Subject: Planning Application BN/66/19/PL

I write with regard to the Subject planning application made by Seaward Properties.
I have attached HM Land Registry documents showing that Seaward do not own the whole of the site they submitted to you in their planning application.
Whilst Seaward's representative and solicitor hastily provided you copies of a plan and letter, and submitted these on the day of the Planning Meeting on the 4th March 2020, they have not produced official Land Registry documents to prove ownership of any land outside the Boundary shown in Red on the first attachment (Transfer from Croudace Homes for £1) or shaded Blue on the second attachment.
I therefore request that you reject this application until such time as Seaward prove ownership of the whole site or resubmit plans for the land within their Title Boundary.

Drainage Strategy Drawing

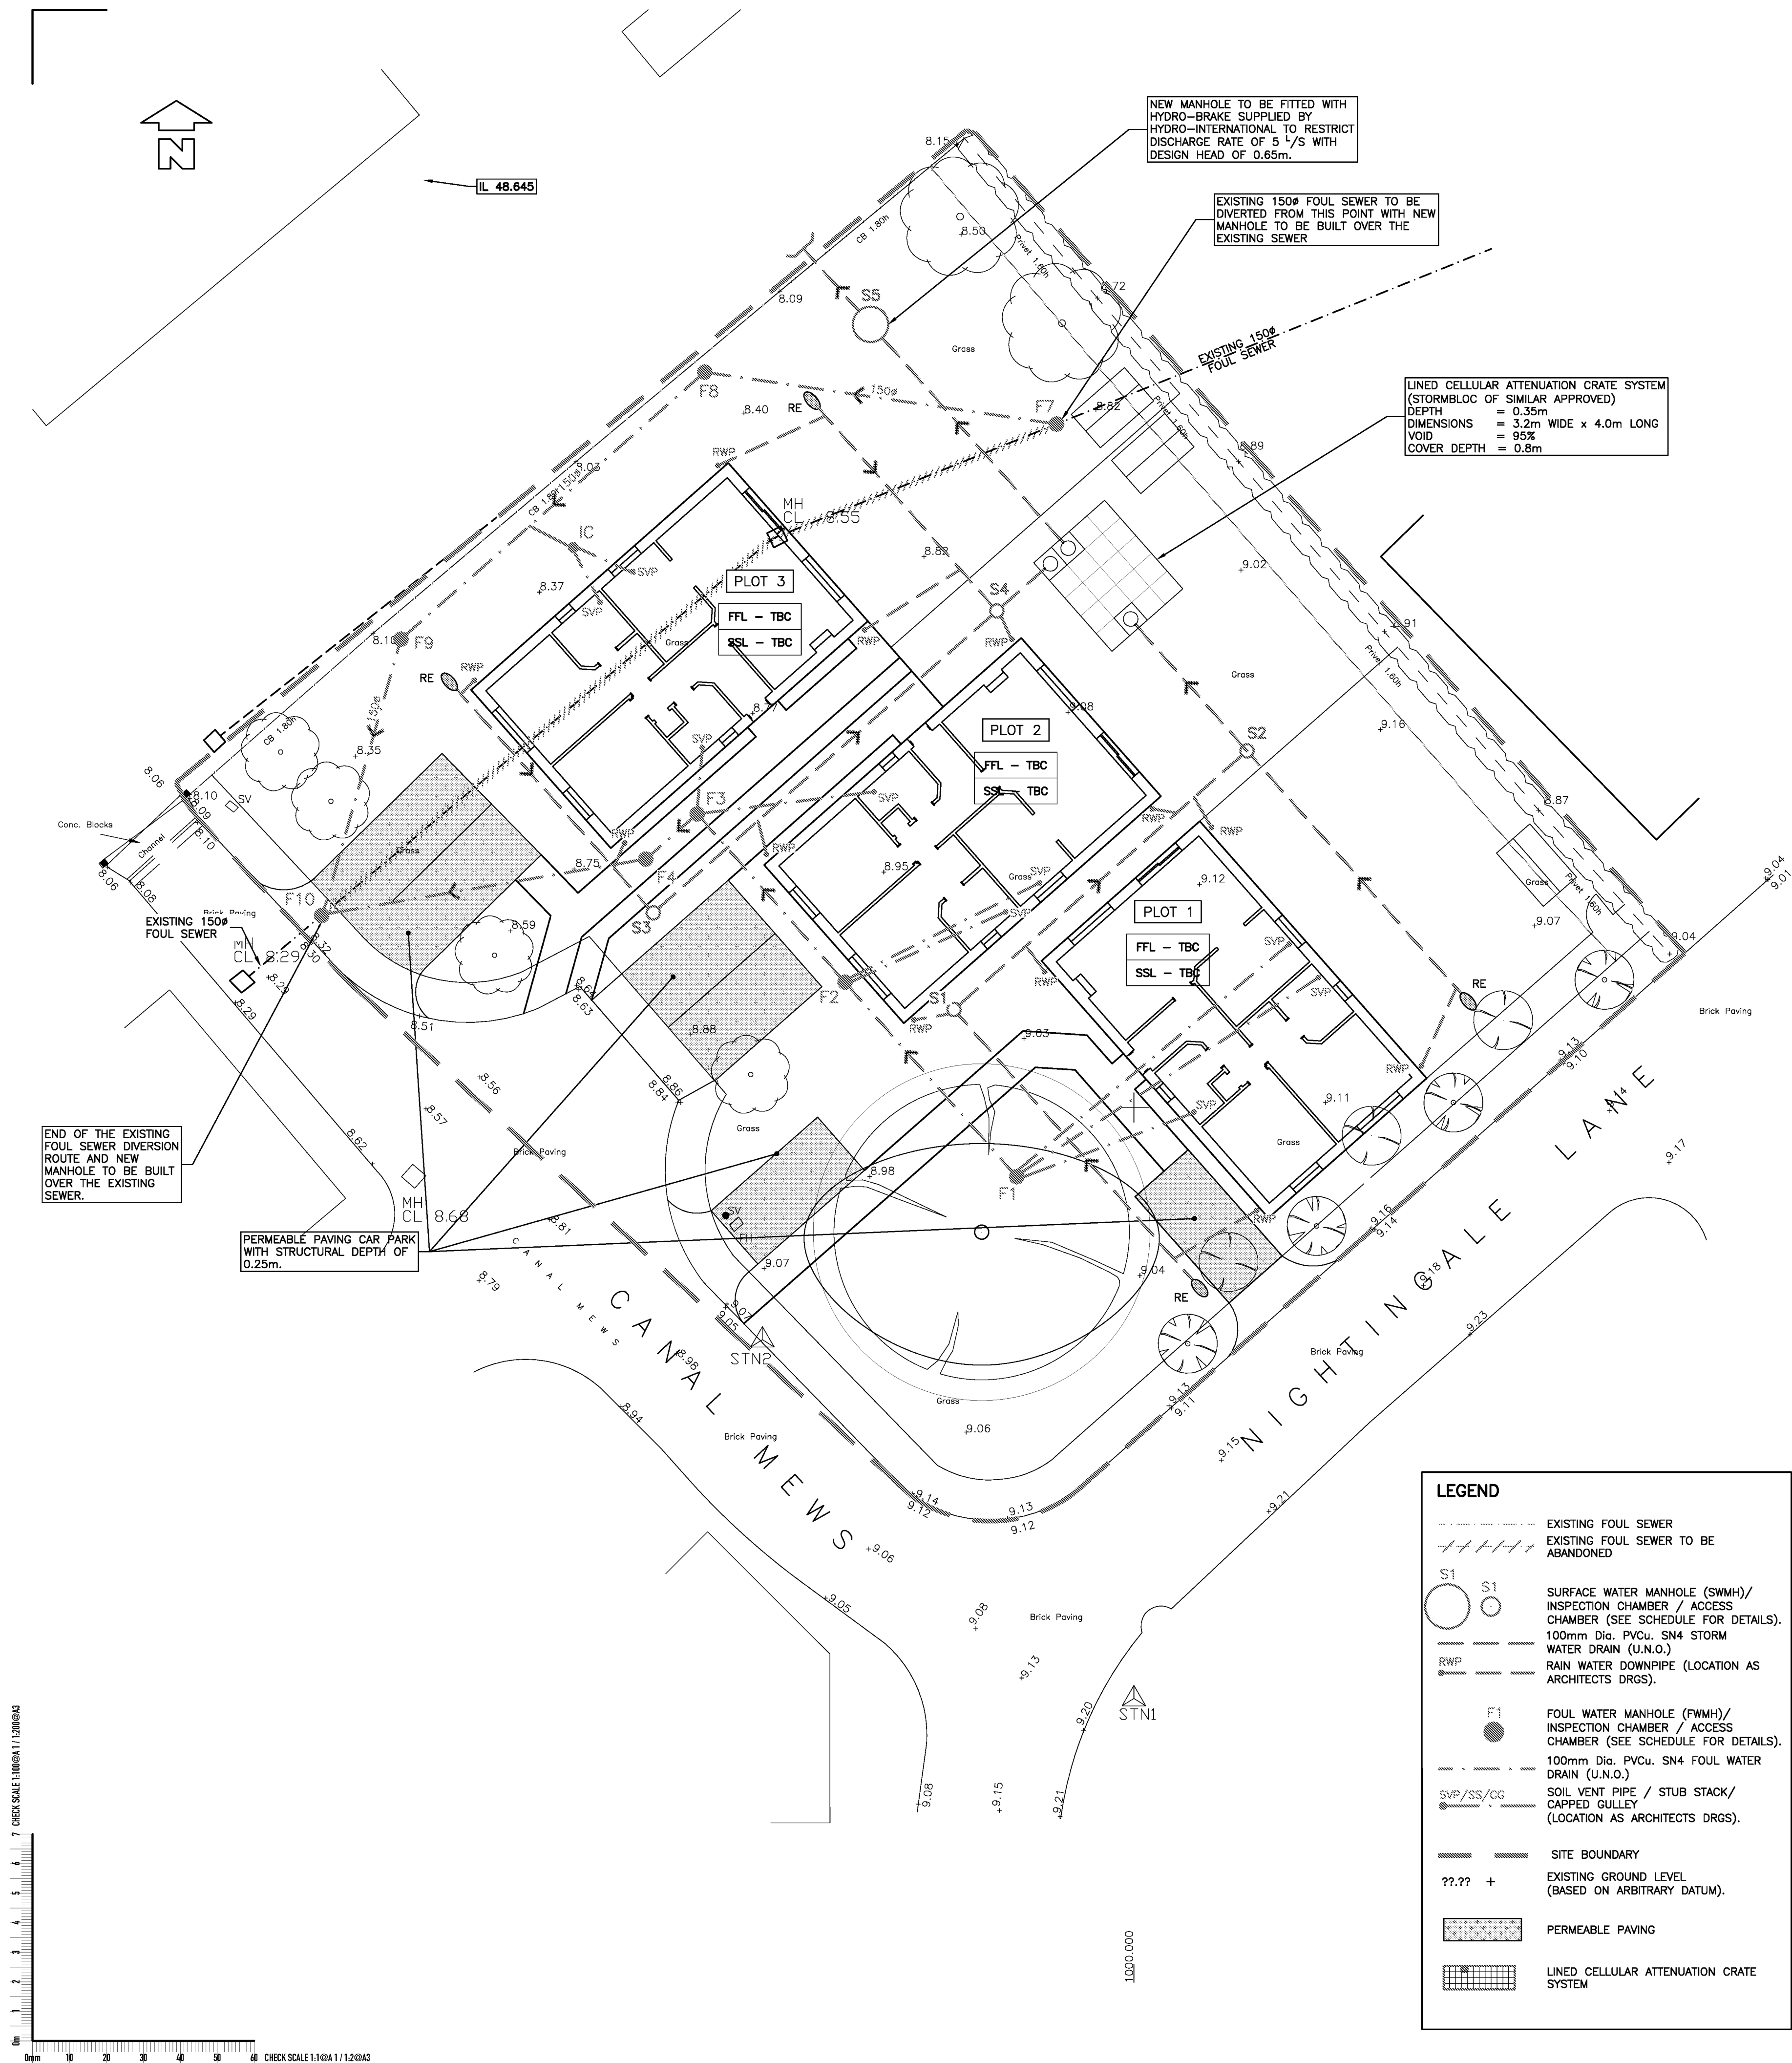
Furthermore, the application as it stands involves moving a Private sewer. They do not have permission to do this. The sewer is already at capacity. Their application shows moving the Private Sewer and putting 4 tight angles in. This will create resistance to flow in a system that has previously had issues with flow.
In addition, the sewer has a 1:150 drop as per planning permission granted to Croudace Homes for the original Arun Place Development. Increasing the length of the run by around 30% will reduce the gradient of the sewer and take it outside original planning regulations.
The reduced gradient and addition of 4 angles would cause reduced flow and resistance within the sewer and cause backing up/blockages for the residents of Arun Place.
I therefore ask that you also reject the application, in its current form, until such time that Seaward submit plans that do not include diverting the Private drainage.
